Re: **Framing Issue**
Location: Lot 41 Honeycutt Hills (188 Shelby Meadows, Angier, NC)
JDS Project No.: RDU2500175
Date of Inspection: 01/08/25

Observations

sheet:
S3.0

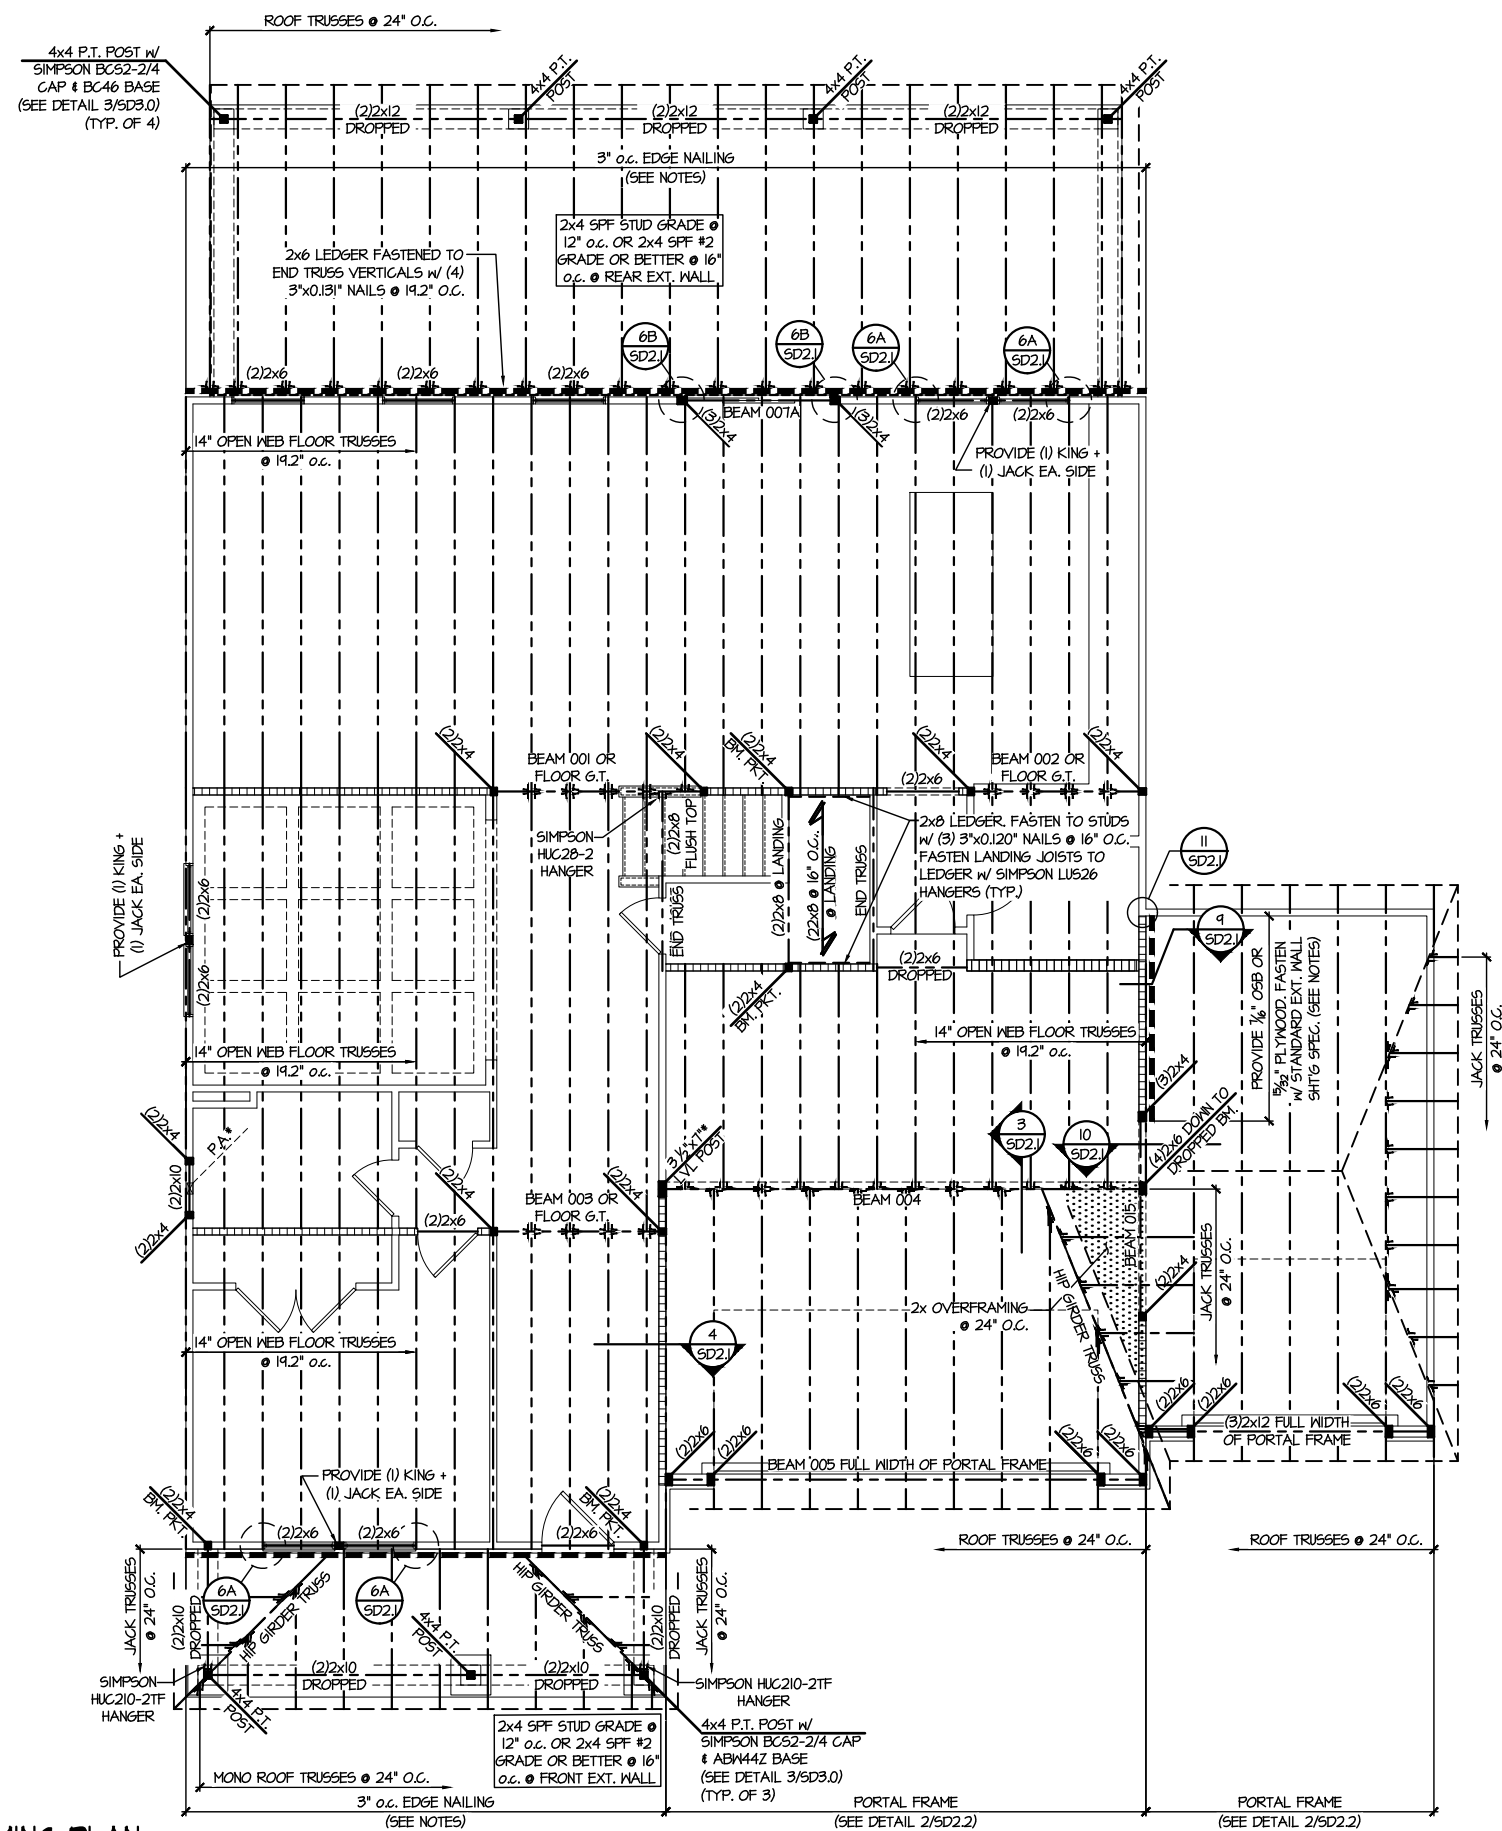
The client requests an evaluation of the LVL that spans approximately 8'-10" between the 2nd and 3rd car garage wall. Plans call for a (3) ply LVL to be installed but the wall is 2x4 and will not support the 3rd ply. The LVL supports a (4) ply left to right girder LVL.

Based on our on-site observations and review, furr out the 2x4 wall and install the (3) ply LVL as per plan.
